**KIRKLEES METROPOLITAN COUNCIL
INVESTMENT & REGENERATION SERVICE**

DELEGATED DECISION TO DETERMINE APPLICATIONS FOR LISTED BUILDING CONSENT

Reference No:	2024/65/91037/W
Site Address:	Edgerton Cottage, 15, Edgerton Road, Edgerton, Huddersfield, HD3 3AA
Description:	Listed Building Consent for replacement windows and doors (within a Conservation Area)
Recommending Officer:	Sebastian Pickles

DECISION – GRANT LISTED BUILDING CONSENT

CASEMENT

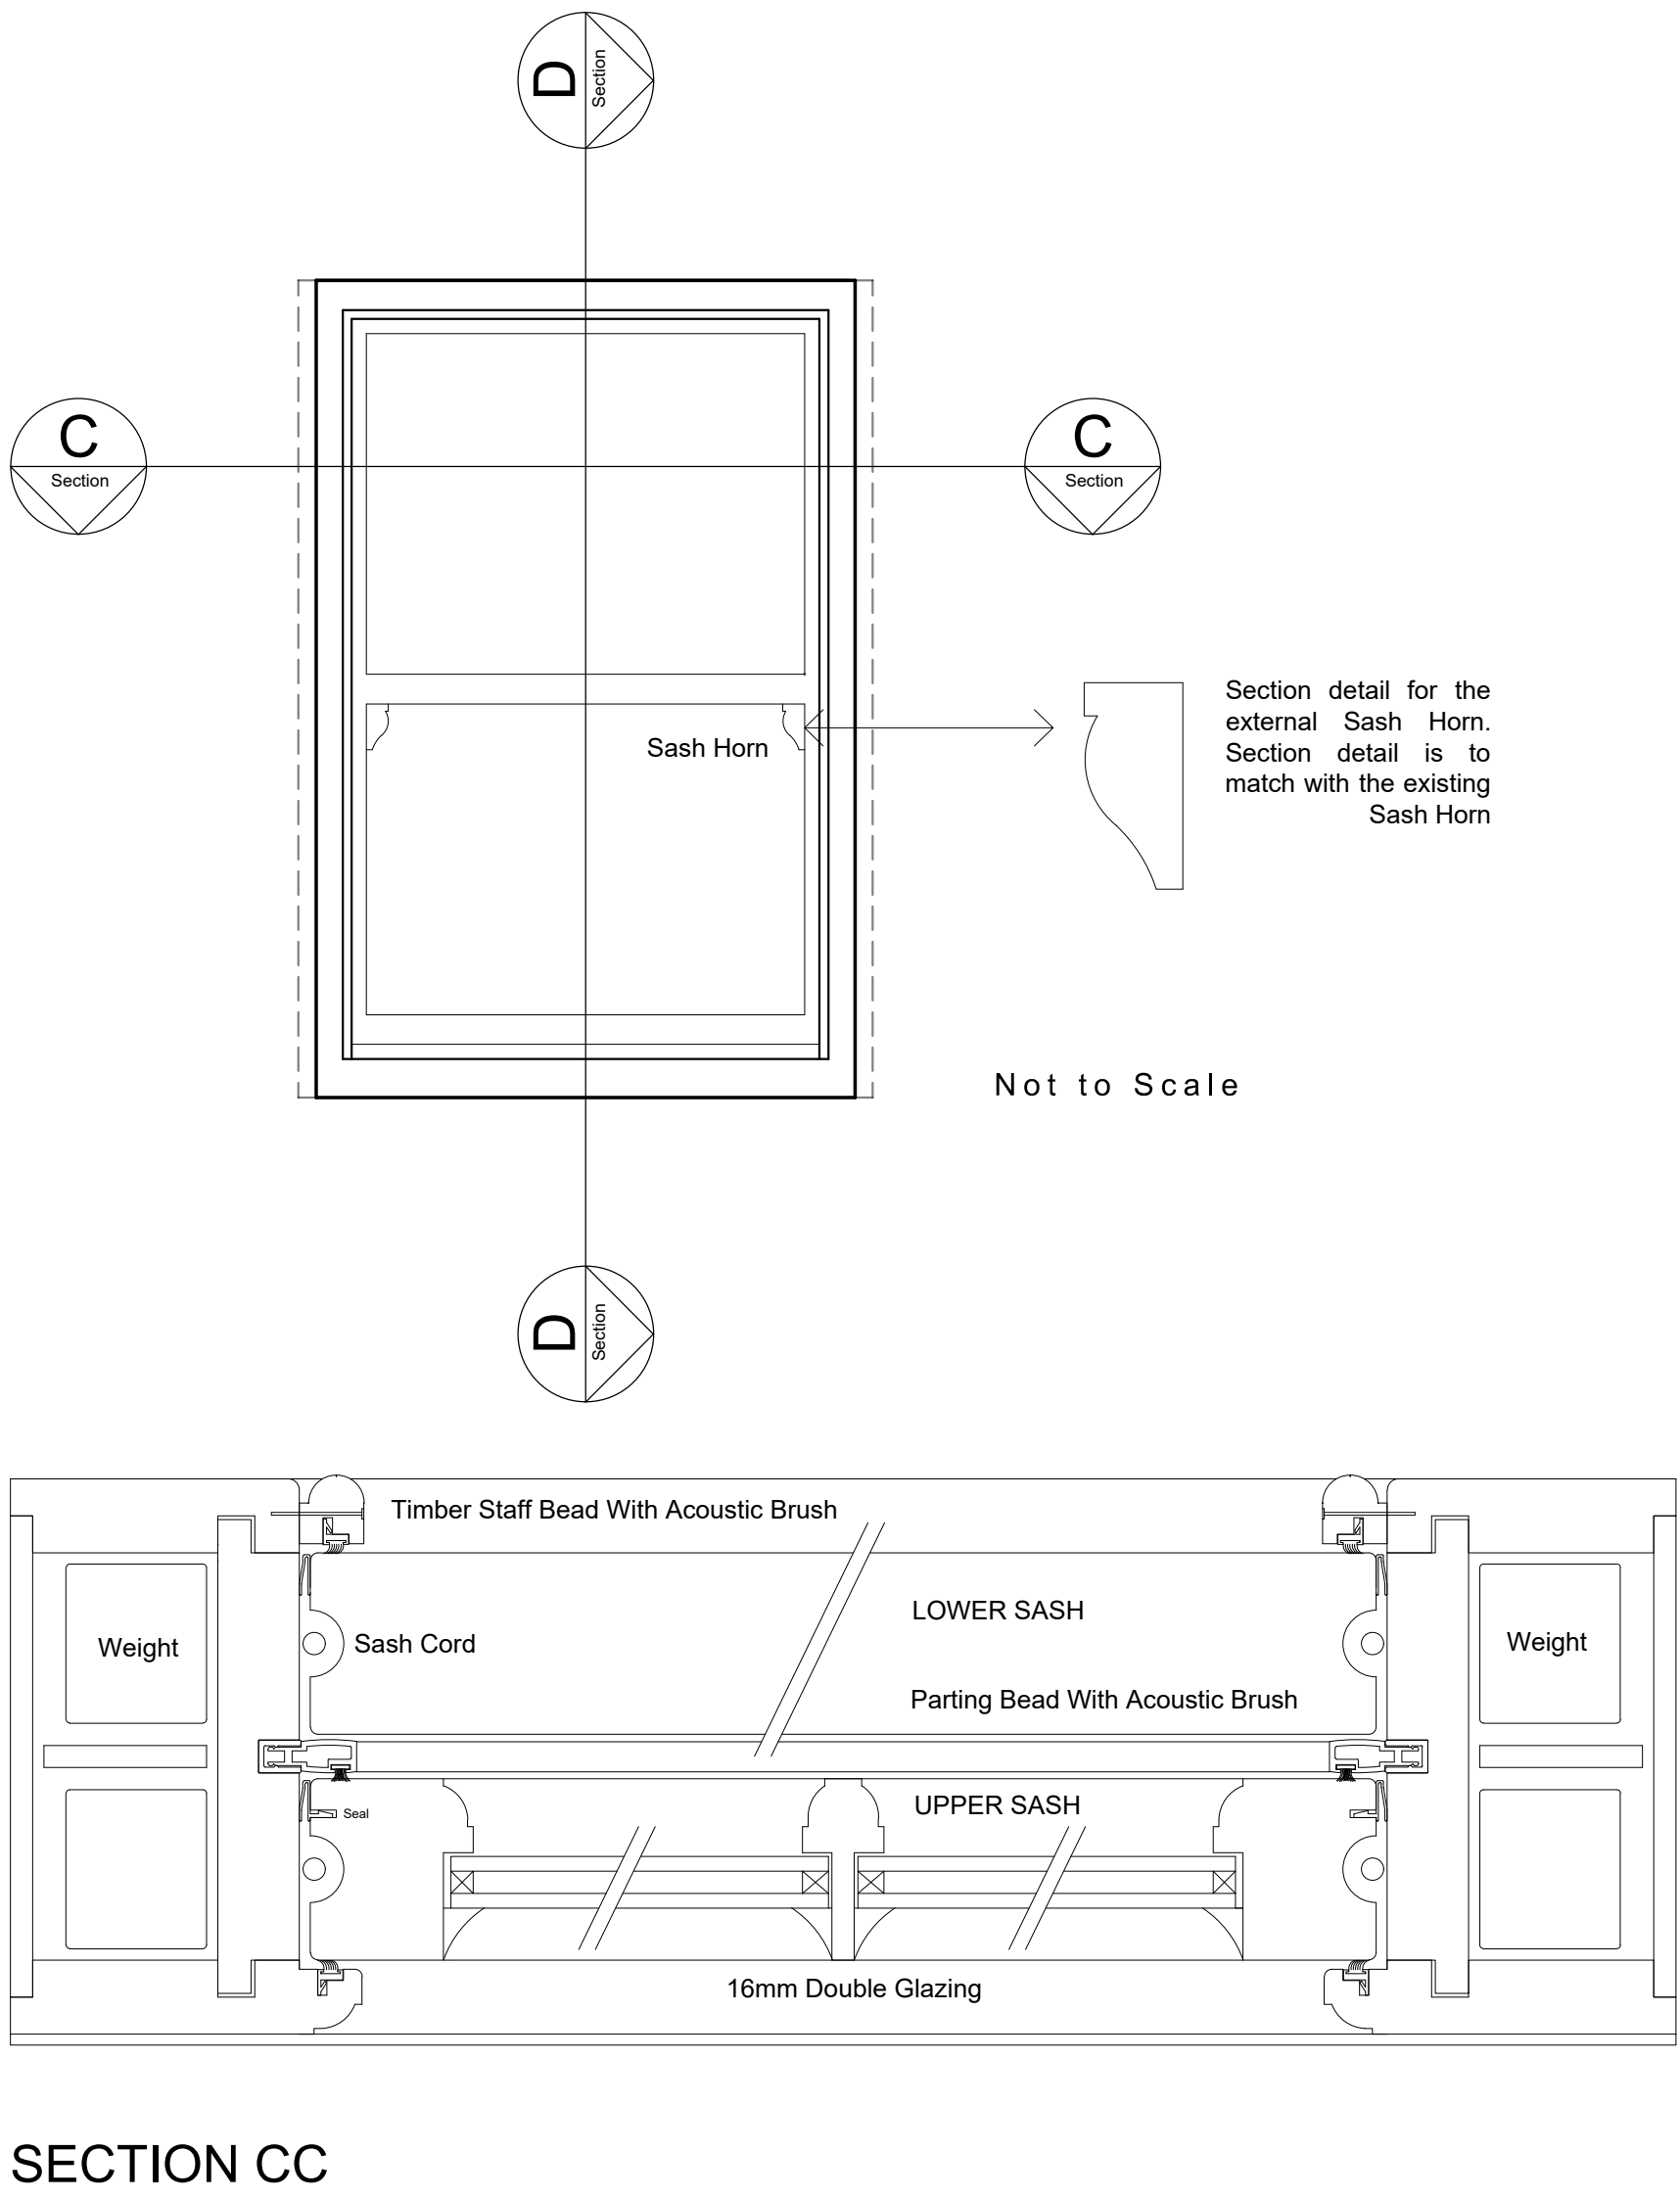
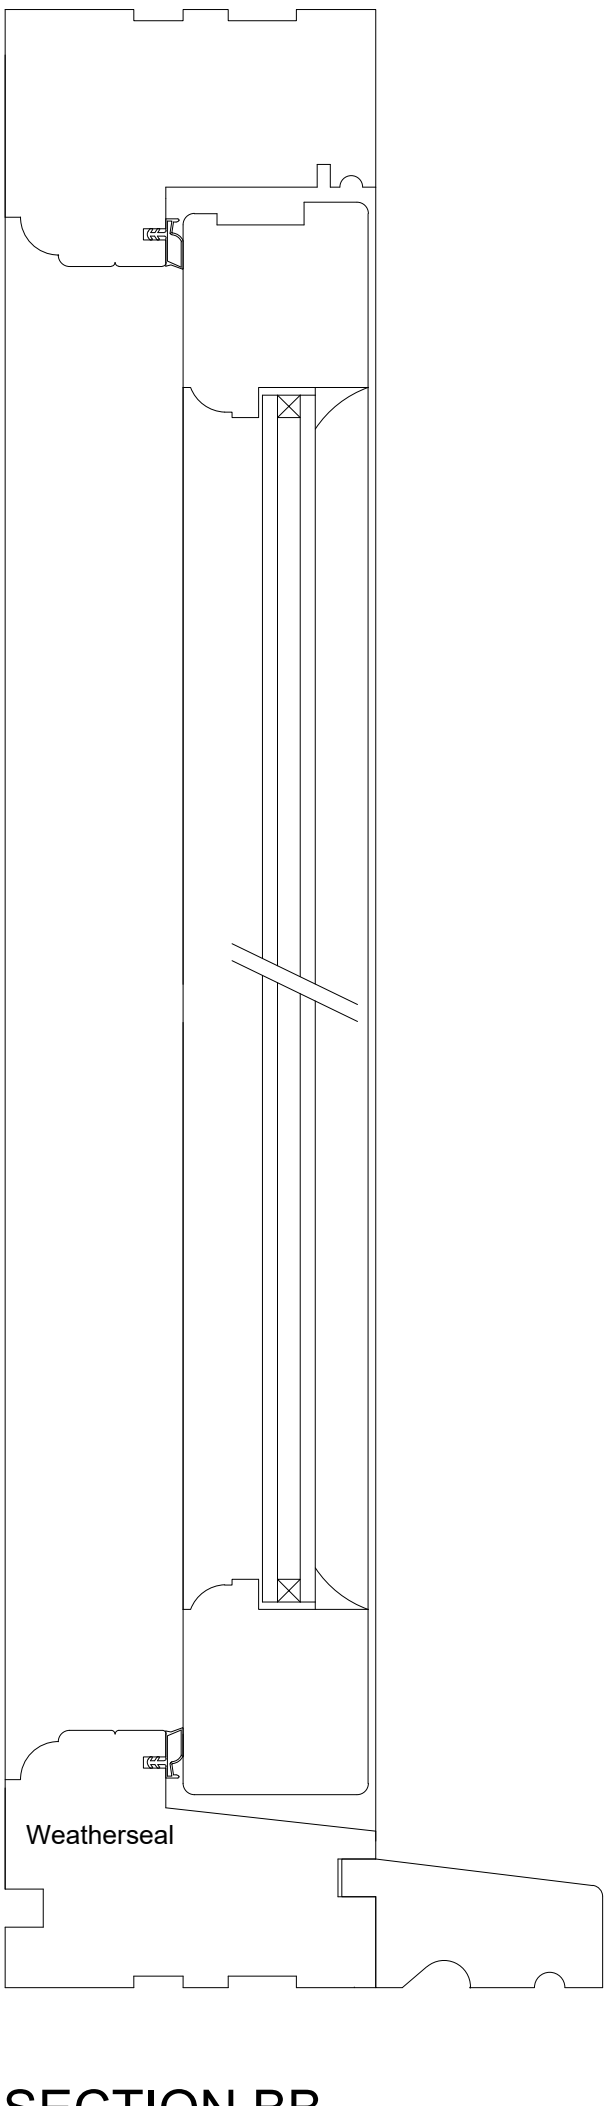
As stated, the proposals are for the replacement of the existing windows and doors to the building. While this will see the loss of the existing frames, it is considered that this will not have a detrimental impact on the character and significance of the building. The replacement frames will be of a match to the existing ones in every respect, saved that the new frames will have slim line double-glazed units. The replacement frames are to be putty finished which again will ensure there is a matching appearance to the existing.

3. Notwithstanding the submitted plans, joinery details of window 15 as shown on plan 2466-D-20-002 – A shall be submitted to the Local Authority for approval in writing. The joinery drawing shall be submitted at a scale of 1:20 and shall include both section and profile details of the proposed window. The works shall be completed in accordance with the details.
